## **Submission at the invitation of An Bord Pleanála on ABP-315173-22**

**Re:** Construction of a rockfill and earthen reinforcement buttress to sections of the extant embankment wall of the Tailings Storage Facility. An Environmental Report and a Natura Impact Statement (NIS) were received with this application.

**Development Address:** Randalstown, Simonstown and Sillogue, Navan, Co. Meath.

Figure 6.4: Cross section – facility embankment with buttress

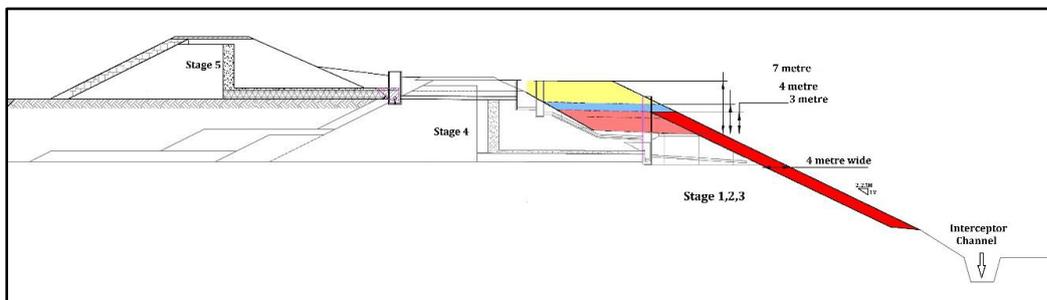
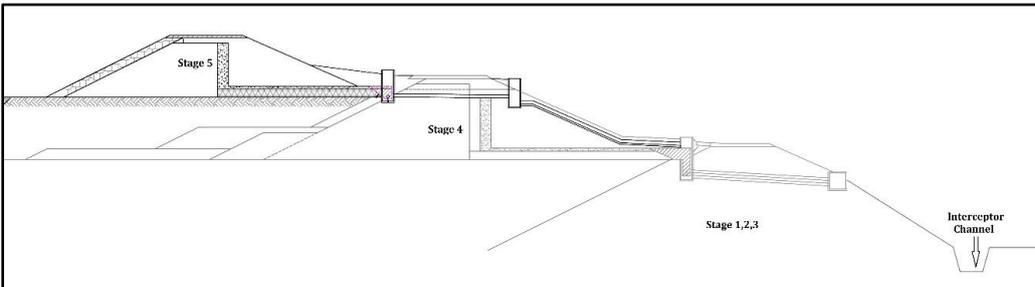
The Tailing Dam construction of sections 1 to 5 are of the upstream construction method. This involves building the next lift of the dam wall on the hydraulically placed material. The upstream methods uses least materials for the dam wall but is the least stable.

The proposal is to carry out remedial works to dam of upstream construction and to use it to impound water keeping the slurry deposited in a wet state indefinitely.

2.1 The application contains insufficient information to describe the characteristics of the tailings pond contents and the retaining structure.

At the very least all calculations and all geotechnical test data should be put before the interested public and An Bord Pleanála.

The application fails to exhibit calculations, test data, return periods for peak events and calculations, along with a compliance statement with various Eurocodes.
